From: Michael Eastham <Michael.Eastham@arun.gov.uk>
Sent: 06 October 2020 12:33
To: Planning.Responses <Planning.Responses@arun.gov.uk>
Subject: FW: Y/82/20/RES - Land South of Ford Lane and East of North End Road, Yapton

Please upload onto Ocella the email below which is a further consultation response from **ADC Greenspace** to reserved matters application **Y/82/20/RES** - Land South of Ford Lane and East of North End Road, Yapton.

Thank you for sending through the LEAP detail drawing D2831 FAB 00 XX DR L 505 PL04 to work in conjunction with the LAP drawings **Y/82/20/RES** application .

Project Number: D2831 Origin: FAB Zone: 00 Level: XX File Type: DR Role: L Number: 0505 Revision: PL04

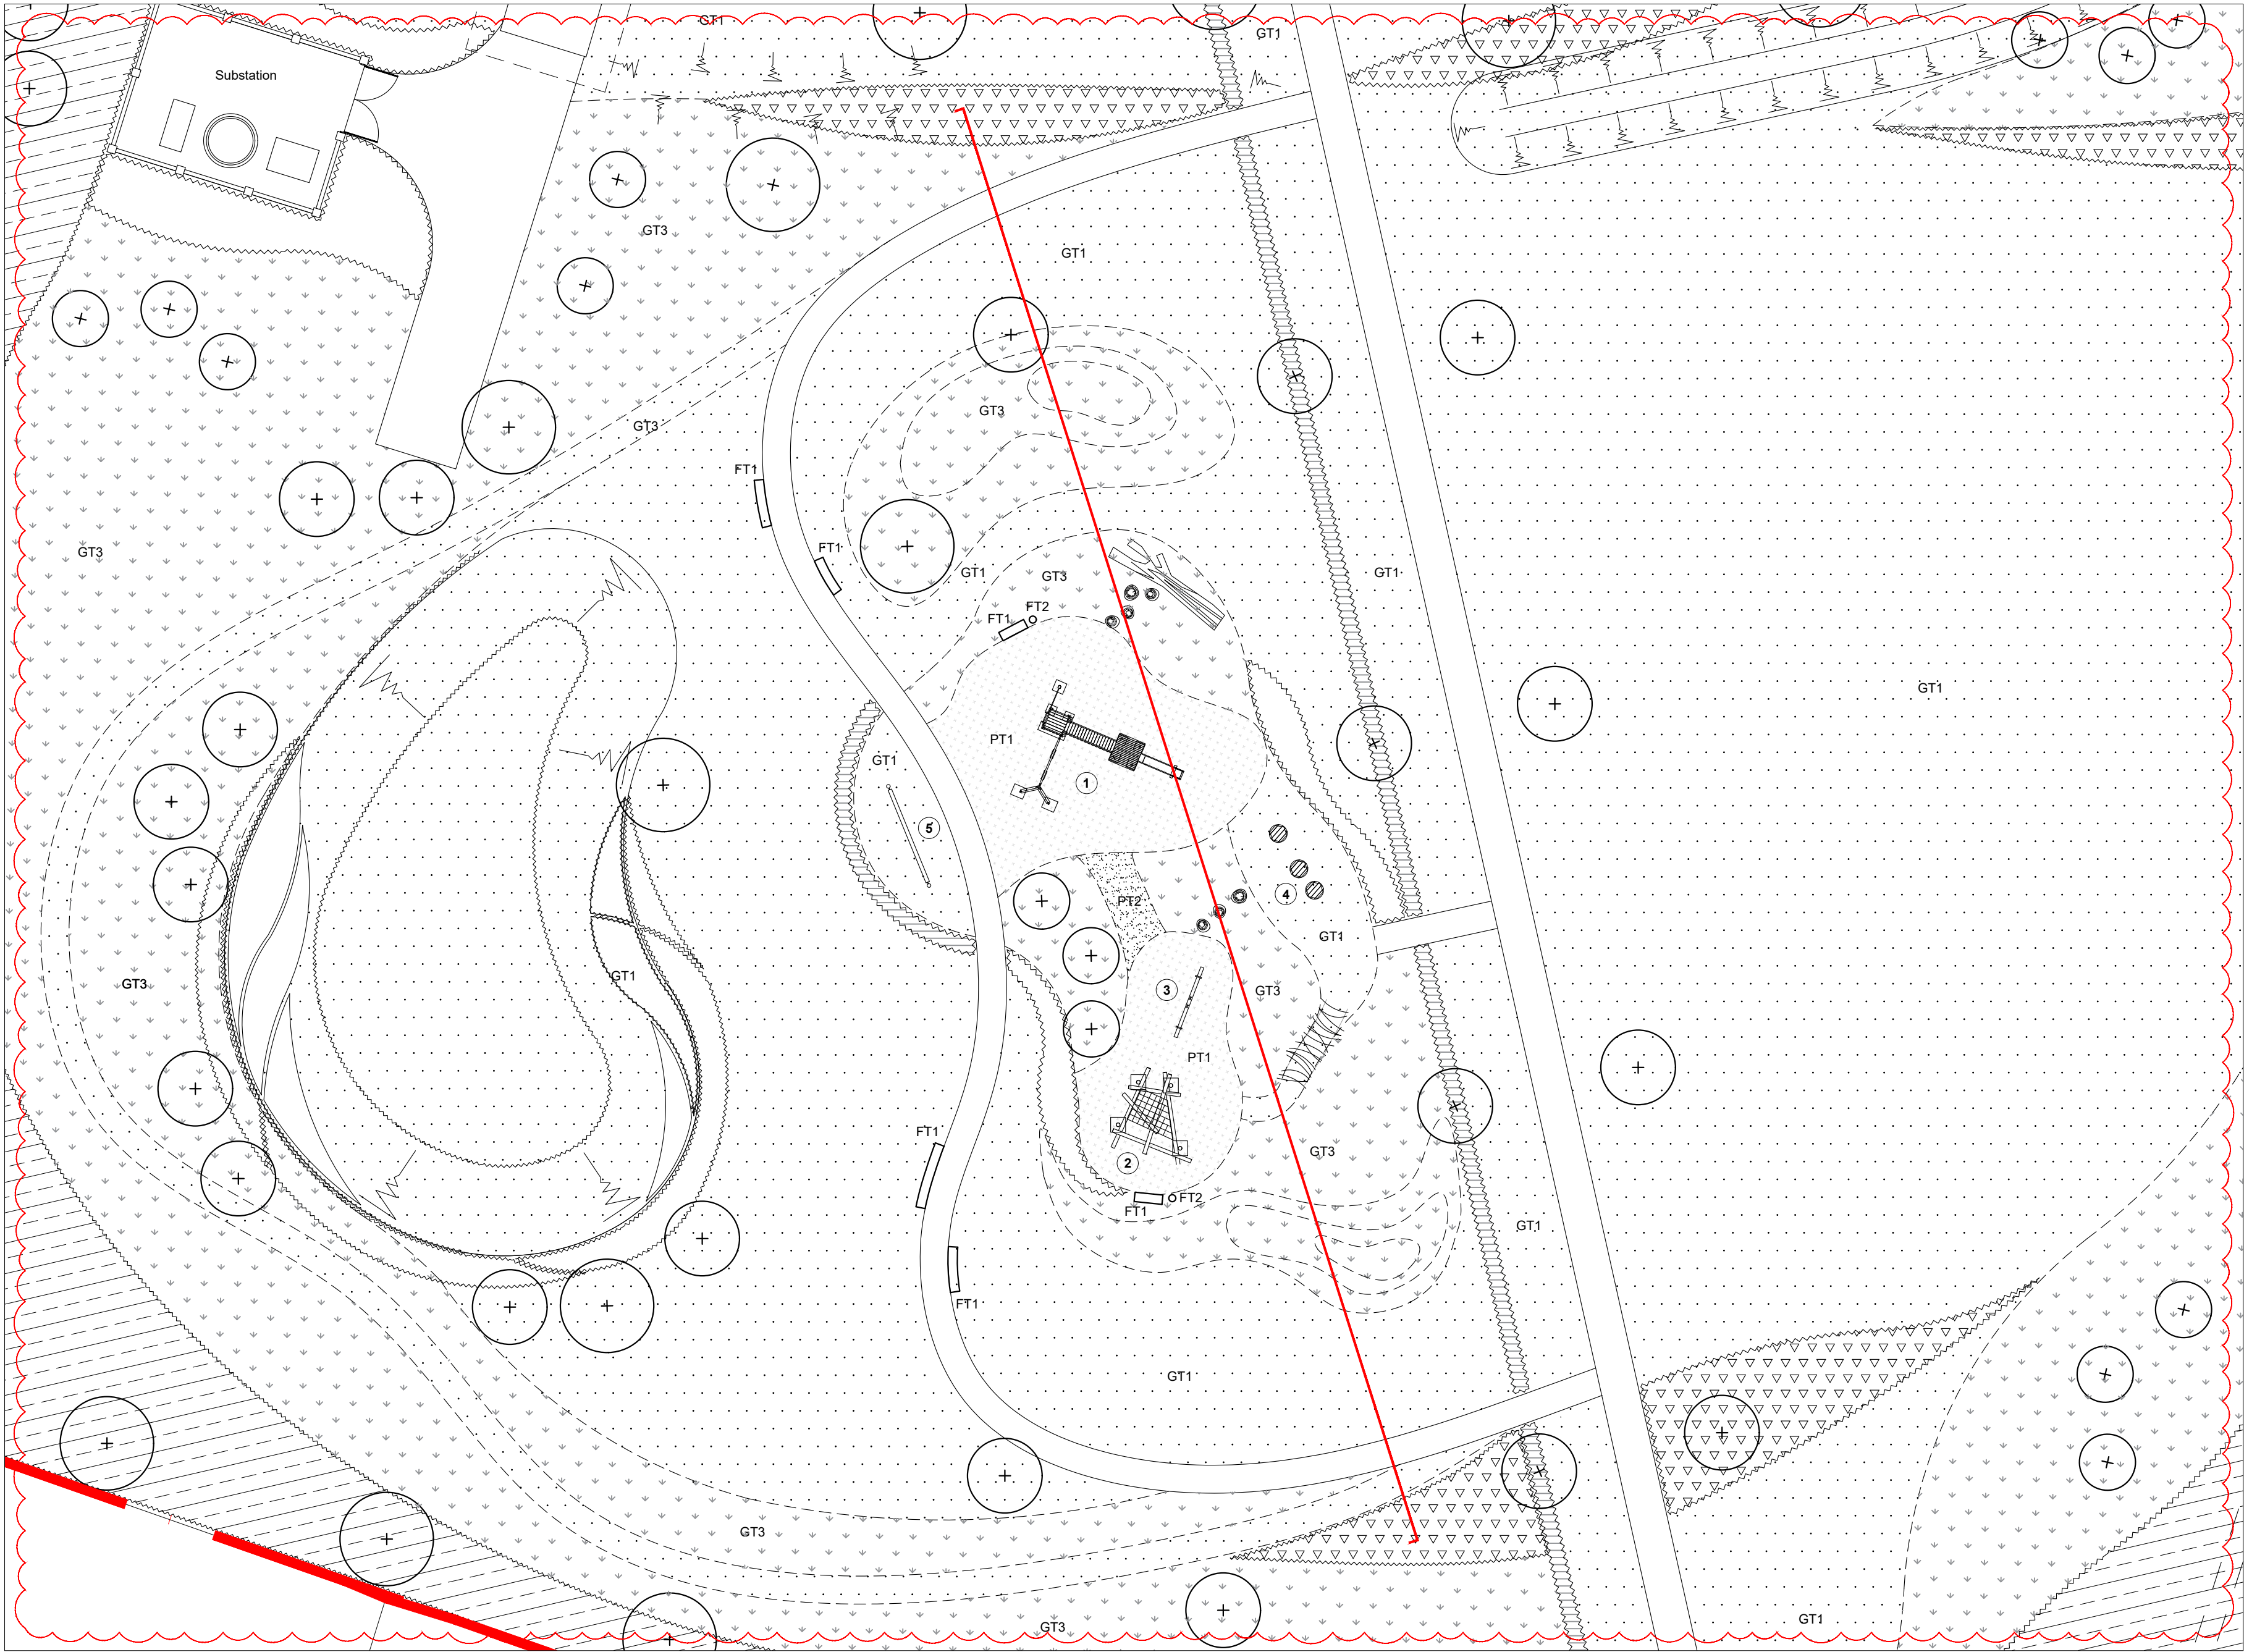
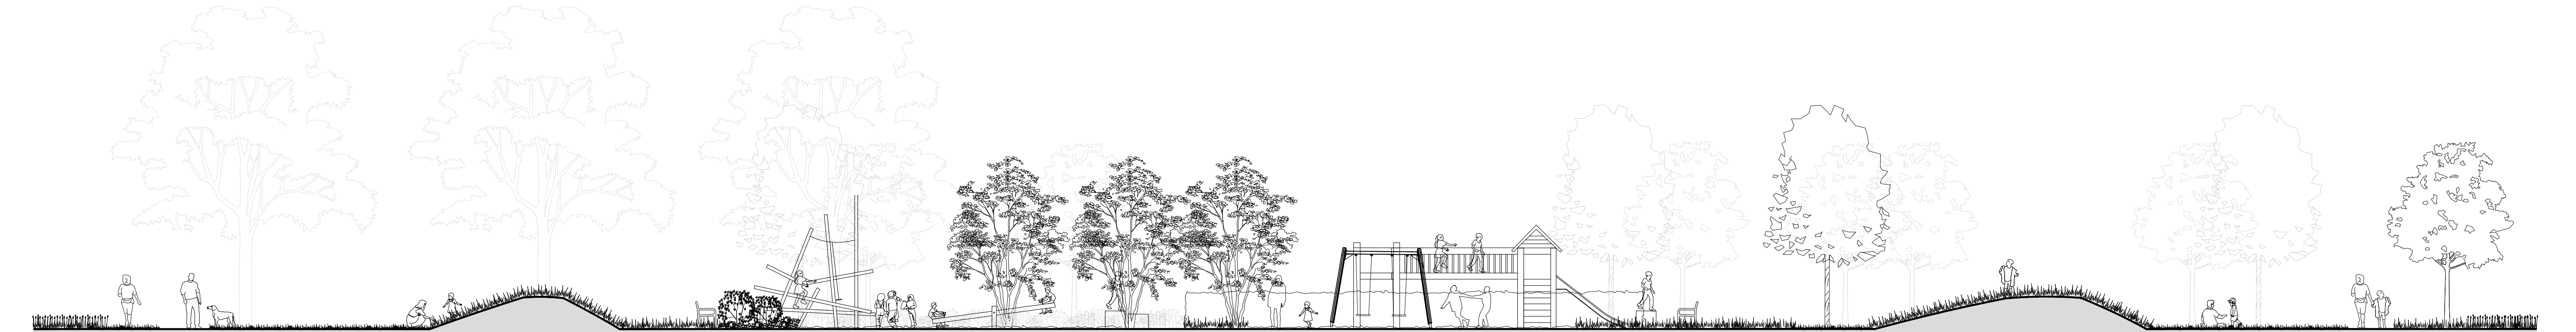
I like mostly what I see with the attached drawing in choice of material (wooden) and the quality of chunky robust exciting pieces.

I would however ask for consideration of 2no amendments:

- Play scheme to include a swing unit as it seems a shame that this is missing and generally forms and intrinsic part of a play area design that can be used by all/ages. I would be happy to see item 3 or preferably 5 removed to make space and swapped with a nest type swing unit (provided the necessary space/clearance). The play offer at present is heavy on balance and climb and **is not terribly inclusive** because of this.
- I would also flag the safety surfacing proposed in areas PT1 G Paving Type 1 Play gravel Safety Surfacing. (Loose fill material would not be supported if it were to be LPA adopted, due to ongoing maintenance requirements) Although aesthetically pleasing we would favour the use of a rubber crumb surfacing instead, subject to play company approval of appropriateness.
